Lr.No. A1/3303/93

Sub: MMDA - Planning Permission - Construction of residential building at New Door No. 87, Thiruvalluvar purem 2nd street, Cholaisadu, Puliyur village - remittance of Development charges and A.C. charges - regarding.

The proposal received in the reference cited for the construction of residential building at Plot No. New Door No. 87, Thiruvalluvar purem 2nd street, Cholaisadu, Puliyur village has been examined and found approvable.

DEMOLITION PLAN SHOWING THE EXISTING BUILDING AT OLD DOOR NO. 16A & NEW DOOR NO. 87, THIRUVALLUVAE PURAM 2nd ST. PULIYUR VILLAGE BLOCK NO. 15, T.S. NO. 9 & 4B, P.S. NO. 17/A & 1B, CHOLAR MEDU, MADRAS. S. No. 5, 5/2.

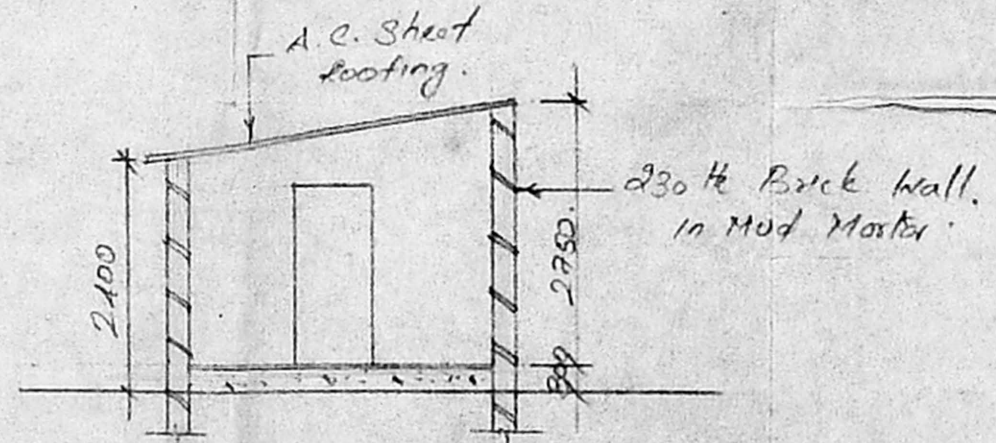
3. The payments received after one month, interest shall be collected at the rate of 12% per annum (1% per month) for every completed month from the date of issue of this advice. After remitting the said amount, you are requested to submit the duplicate receipt to Area Plans Unit, and furnish an affidavit in Five Rupees stamp Paper duly attested by Notary Public as per the format enclosed. Planning Permission Application will be returned unapproved, if the amount are not paid within the stipulated time. You are also requested to furnish the revised plans of 5 sets each by restricting the mezzanine floor.
